WEST SUSSEX COUNTY COUNCIL CONSULTATION

TO:	Arun District Council FAO: Ms Myer
FROM:	WSCC - Highways Authority
DATE:	22 December 2021
LOCATION:	Land between 32 Downs Way and 2 Ambersham Crescent Angmering BN16 1AB
SUBJECT:	A/253/21/1/OUT Outline planning application with all matters reserved for the erection of 1 No bungalow dwelling with off street parking and private amenity space.
DATE OF SITE VISIT:	n/a
RECOMMENDATION:	Advice
S106 CONTRIBUTION TOTAL:	n/a

West Elevation 1:50

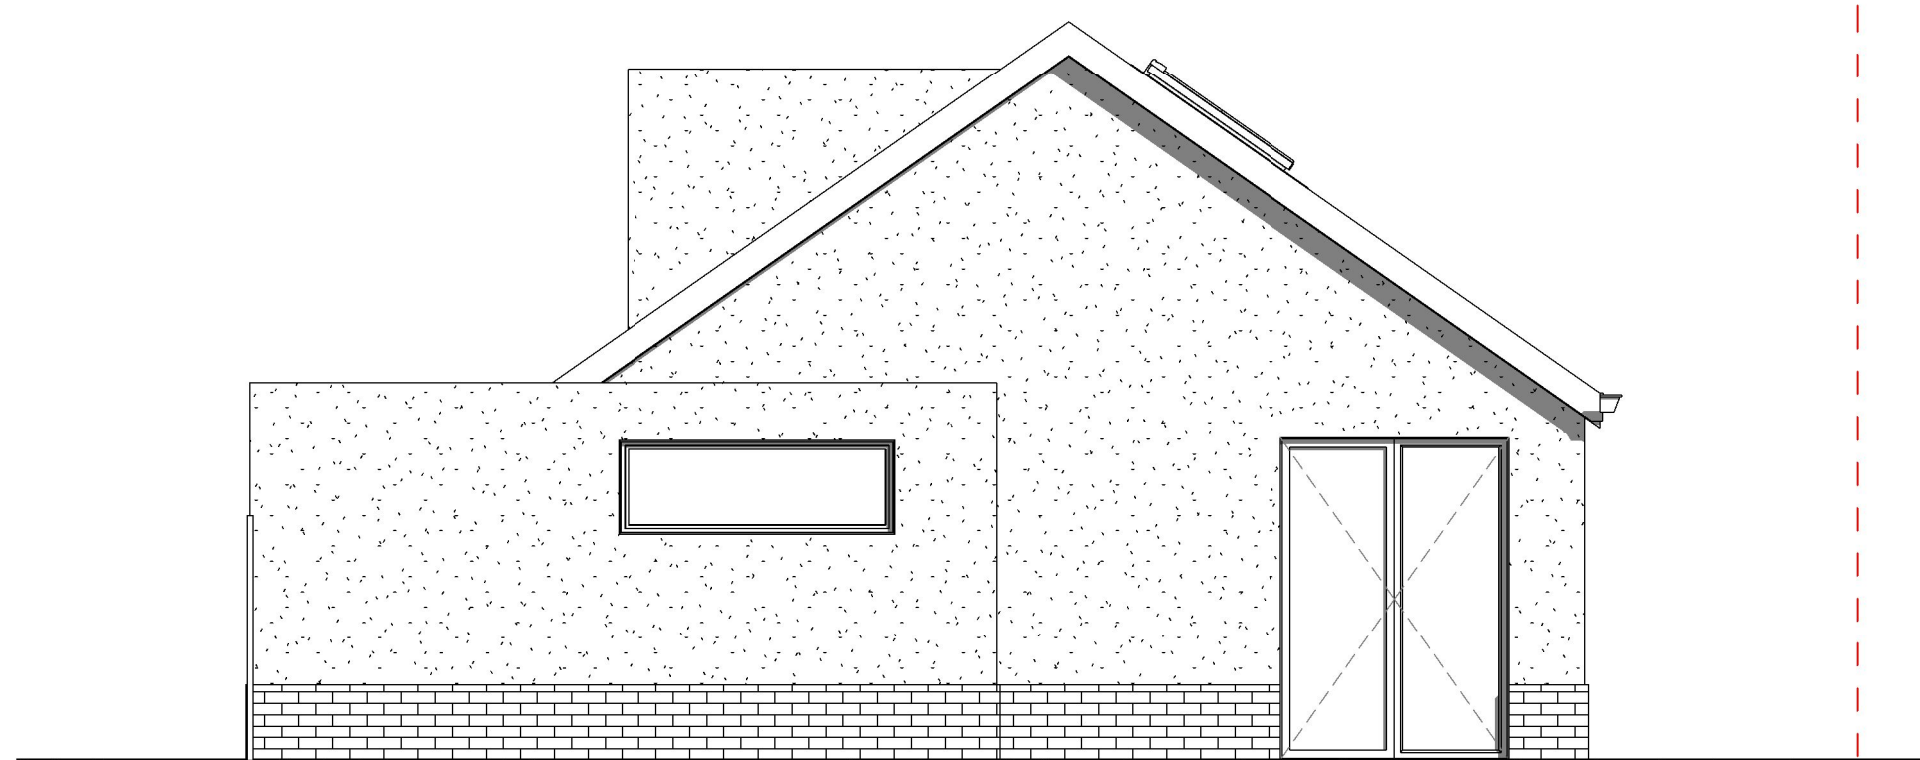
The indicative plans provided detail that the application site, and indicative physical build, is on land considered public highway. As such in order to not result in a physical obstruction to the extent of public highway and be subject to enforcement action the land required to implement the application will need to be first Stopped Up.

An internal 'in principle' consultation process has taken place and it has been concluded that Stopping Up would not be supported by WSCC because the land provides an important public amenity and there may also be services and other highway assets underneath that require access for maintenance.

The applicant is therefore strongly advised to take this into consideration when it comes to further developing and proceeding with this application. The Local Highway Authority want to make their view on this matter clear at this stage so the applicant is fully aware that if permission is granted it seems extremely unlikely, based on the plans and details submitted to date, that the Stopping Up which would be required to implement the scheme will be granted.

The applicant is advised that the existing public highway to be incorporated into the development must be the subject of a Stopping Up Order. This process must be successfully completed prior to any highway land being enclosed within the development. The applicant should contact the Department for Transport's National Transport Casework Team in order to commence this process:

The applicant is advised that based on the plans and details submitted to date it is considered extremely unlikely that the Stopping Up which would be required to implement the scheme will be granted.
